From: Karl Roberts <Karl.Roberts@arun.gov.uk>
Sent: 20 December 2019 10:06
To: Planning.Responses <Planning.Responses@arun.gov.uk>
Subject: FW: A/100/19/PL - Arundel Acre - response to Highways England

Subject: RE: A/100/19/PL - Arundel Acre - response to Highways England

Subject: A/100/19/PL - Arundel Acre - response to Highways England

RPS Drawing/Figure Number	Rev
JNY10317/01a	-

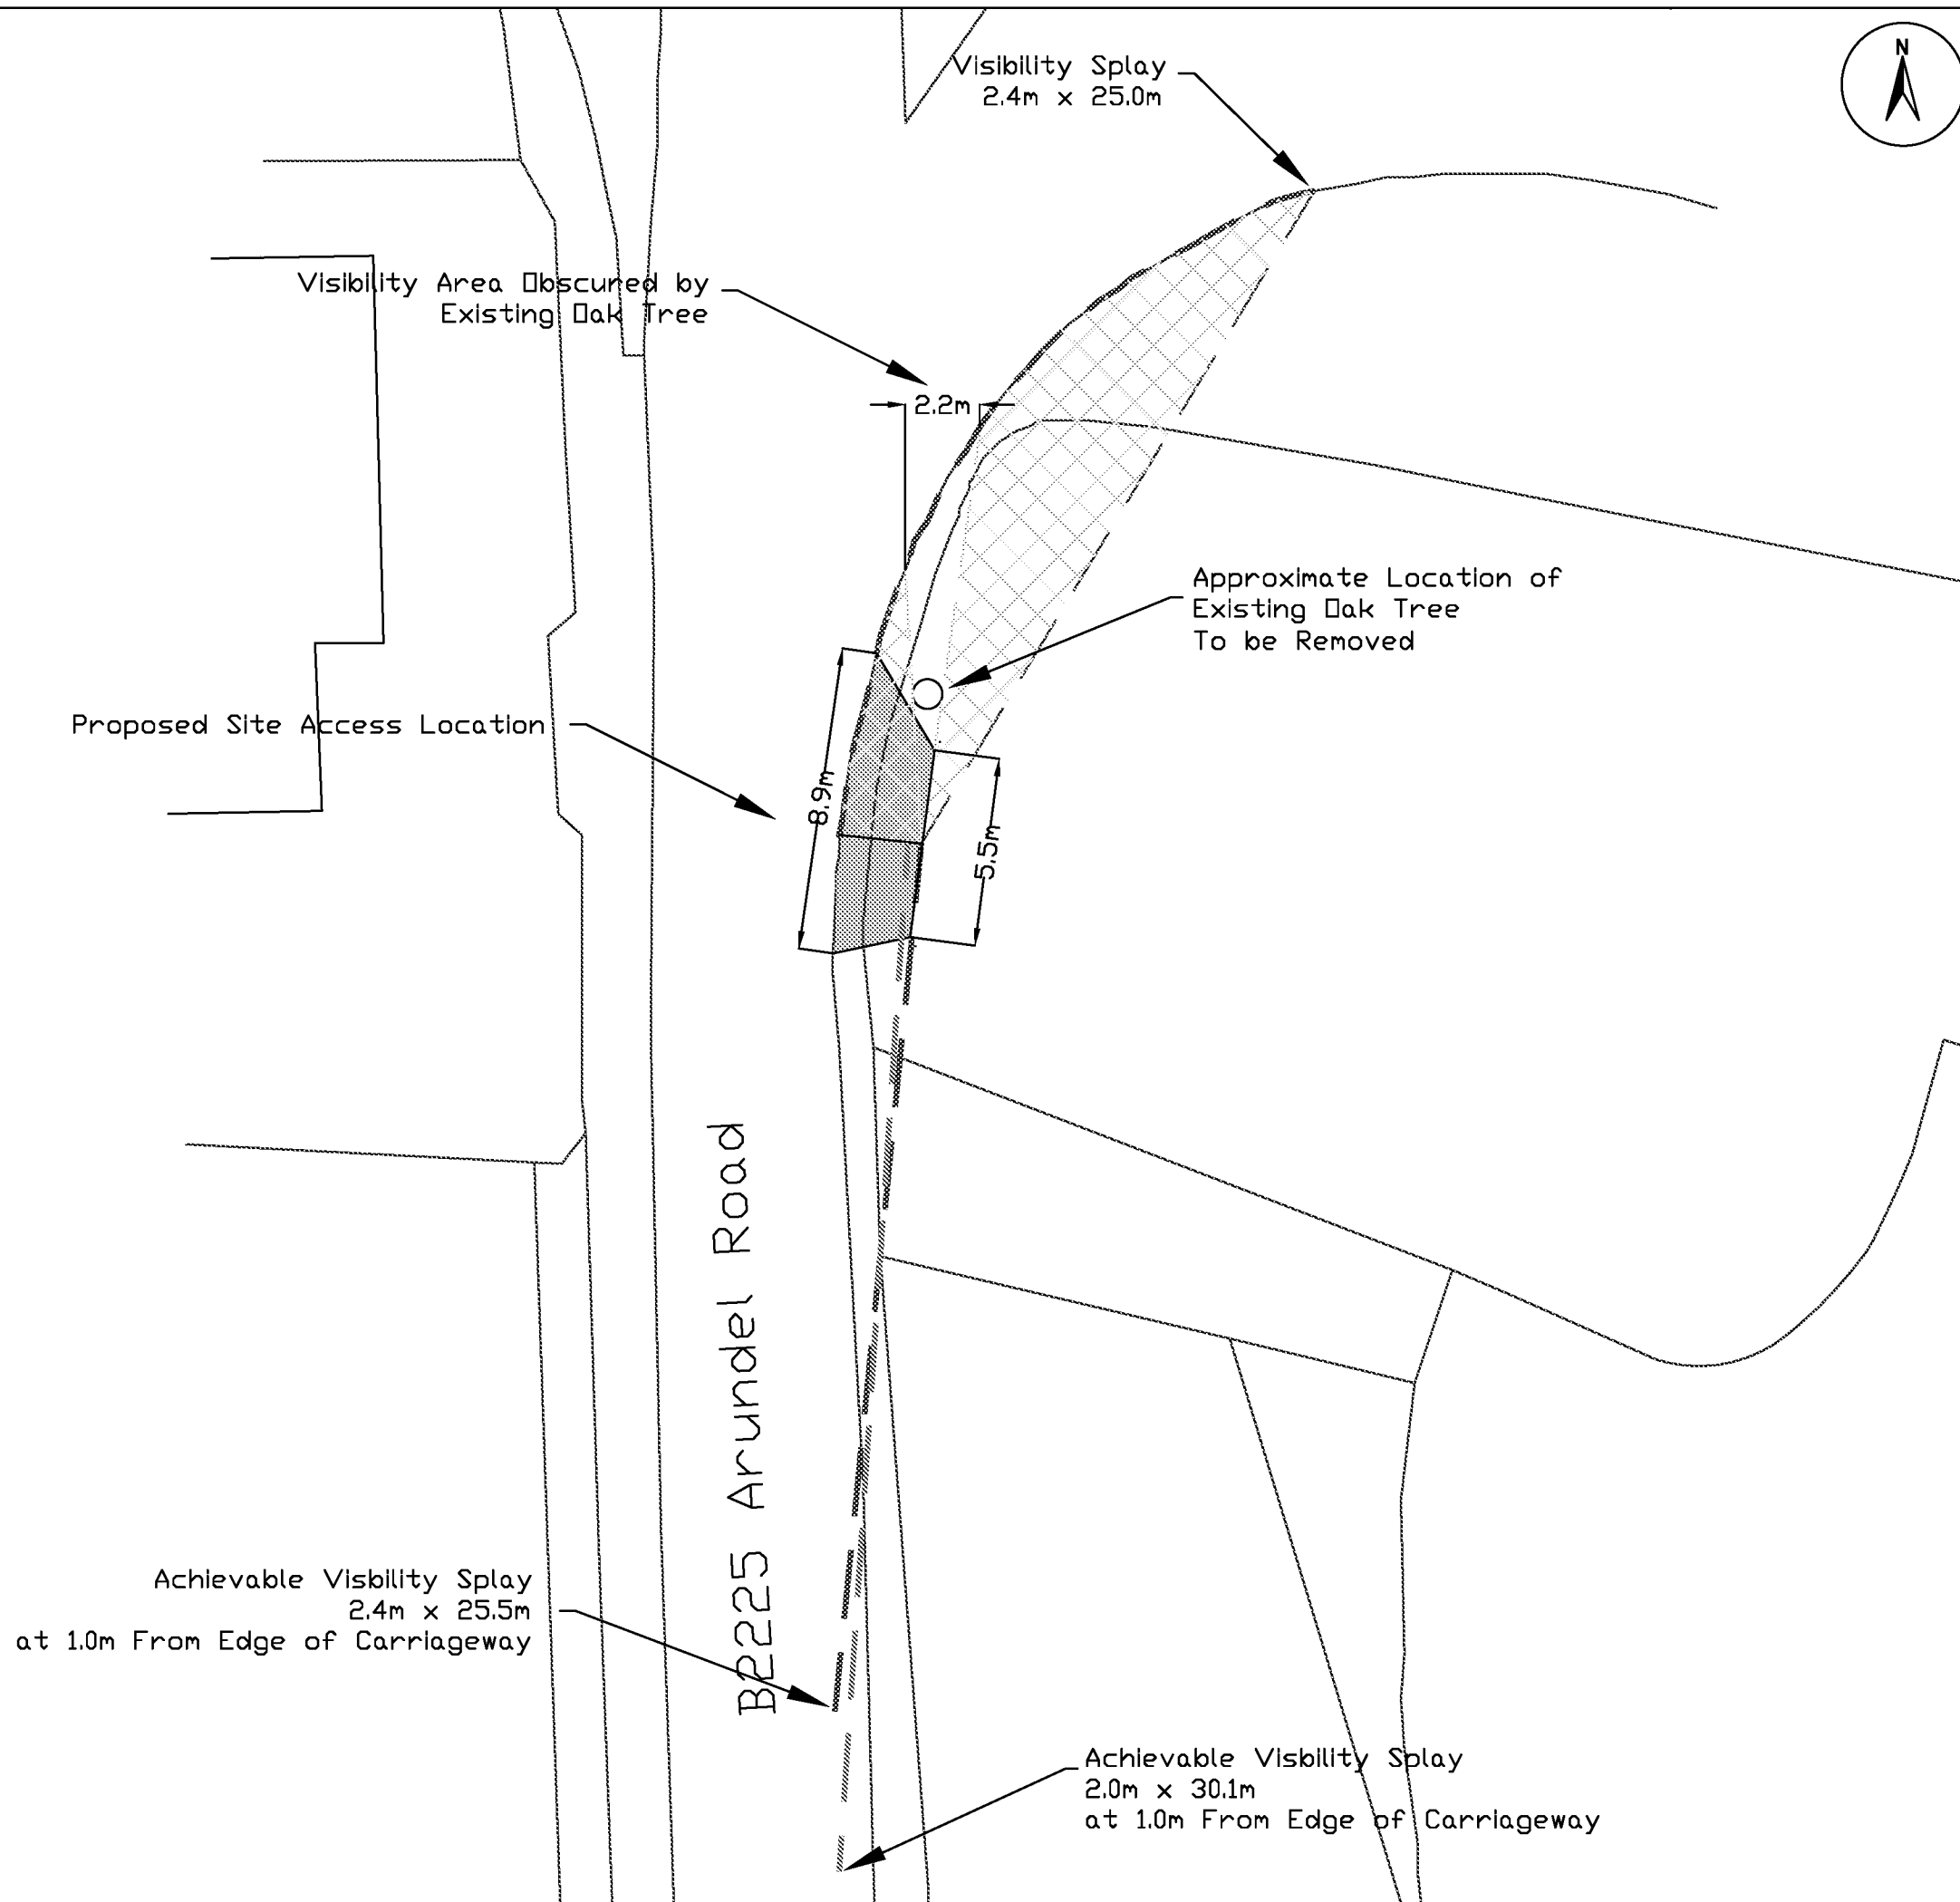
With regard to comparison with the previous application, the proposed access has been moved closer to the A27, and therefore the distance between the A27 junction and the access has been shortened and is not equivalent. The revised access is now on the apex of the bend's radius with associated limited visibility for vehicles manoeuvring in or out of the access.

We have been advised that no further information will be provided at this stage, and therefore, based on the information provided, Highways England will require conditions to be placed on any permission that require a further plan to be provided that shows the visibility splay all the way around the bend (not just from the site access), in order that a Safe Stopping Distance can be achieved around the corner in relation to any part of the vehicle and trailer shown in the swept path plan (Drawing No. JNY10317/02) manoeuvring into and out of the access. In this respect, please note that Manual for Streets is not appropriate for use associated with trunk roads or where speed limits are above 40mph. As such, the visibility splay will need to be provided in accordance with the results of the speed survey and DMRB calculations.

All vegetation within the visibility splay, including the oak tree, will need to be cleared and maintained in perpetuity so that the sightline can be achieved and maintained for the proposal to be acceptable. Such a plan will need to be provided to Arun District Council as the Local Planning Authority, who shall consult Highways England accordingly. As this is a retrospective application, the plan will need to be provided and agreed within 1 month of any permission, with the vegetation cleared before the bird breeding season and within 2 months of any permission.

We are of the view this information will assist Highways England to address the concerns regarding speeds and visibility at the site. We would also like to highlight that attached Drawing No. JNY10317/01a shows the proposed north visibility splay to be 25m and takes into consideration that the applicant has reduced the original hedges to significantly improve visibility, for the overall benefit of highway safety. Such visibility splay is considered to comply with MfS requirements.

You have asked for more information regarding the Oak Tree next to the proposed access - We can confirm that the proposal is to remove the existing tree and to replace it with a suitable specimen within the site. This would improve visibility to the north, towards the A27.
